From: julie gregory [REDACTED]
Sent: 10 November 2020
To: Iqraa Malik
Subject: RE: Request for further information Y/121/20/HH
Attachments: We sent you safe versions of your files; GMC Steve 3.pdf

This application is still invalid as the plans do not measure to scale. The dimensions listed on the proposed plan are inaccurate and the scale bar on the location plan also does not measure to scale. Please amend.

Dear Mr. Crowther
I hope that this is all the information you need for our application for a drop kerb.
Kind Regards
J GREGORY

Proposed Plan - 1:100 @A1

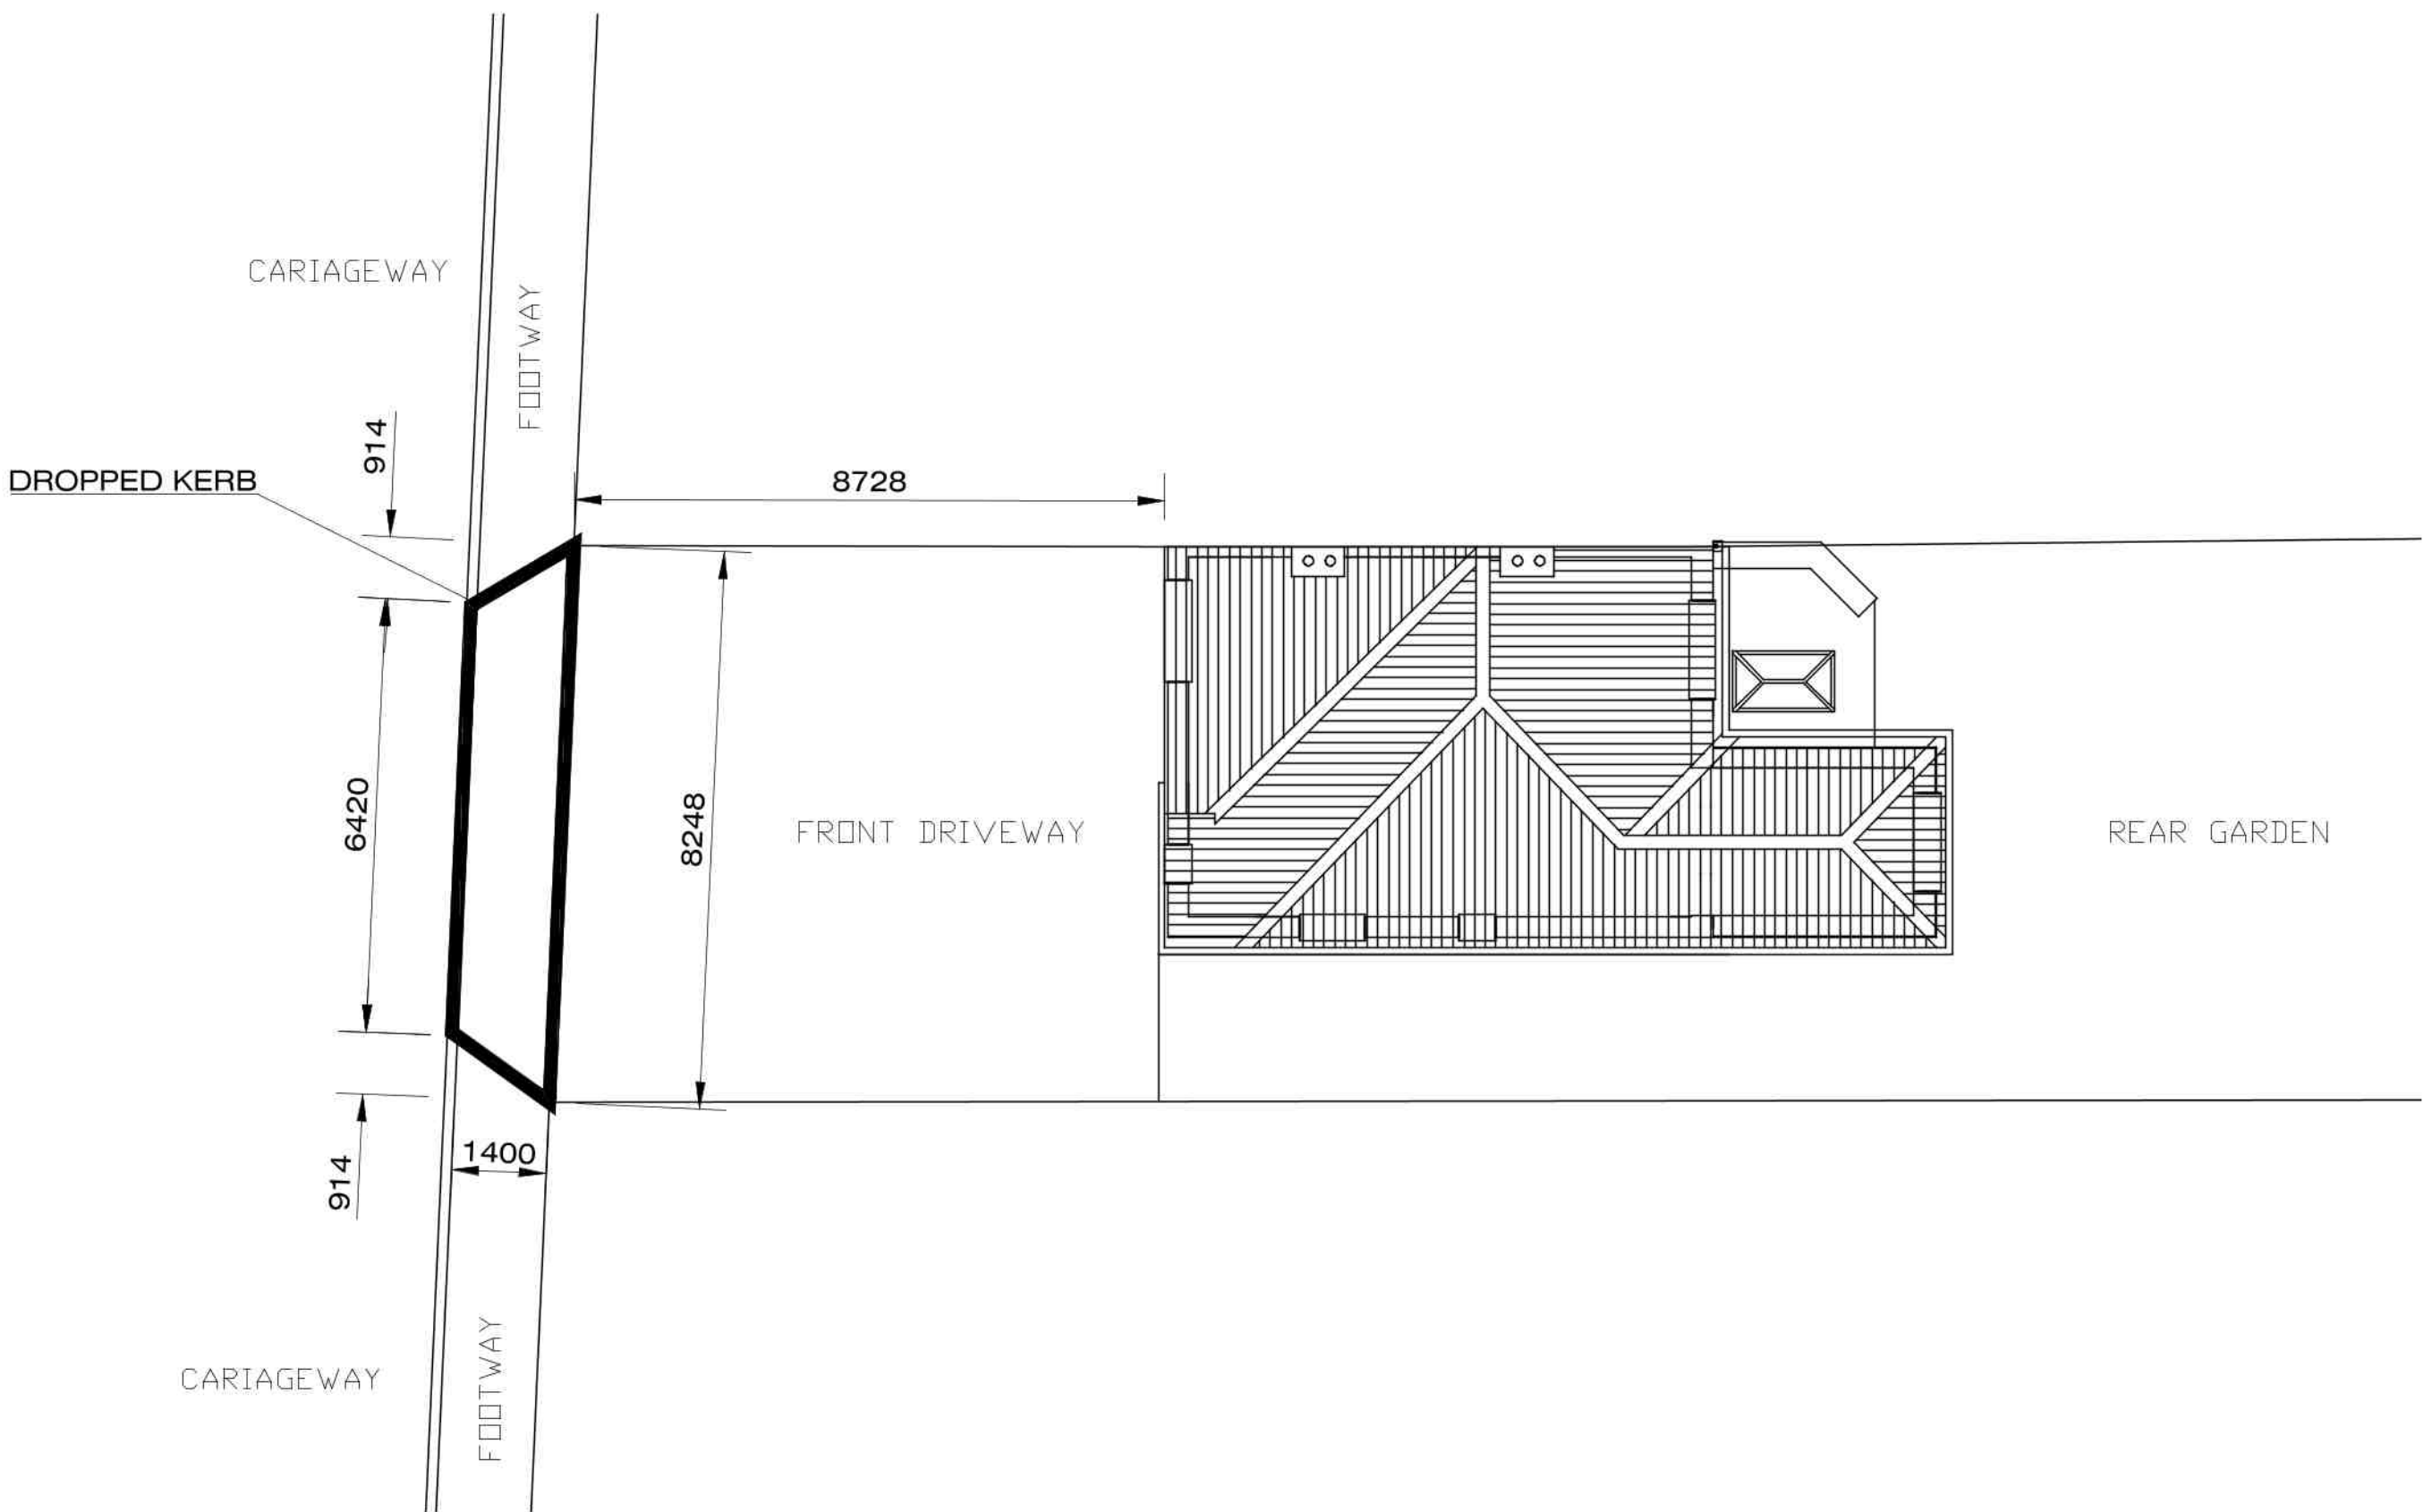
I have measured the plans and they still do not measure to scale. I have attached a screenshot of the incorrect measurements. Please amend.

I am so sorry for miss understanding but apparently the file is an A3 file but the drawing is an A1 so if printed off as A1 apparently would be correct and the digital pdf your taking from is half the size. So they have now given this to me to send and hoping at last we have it right .
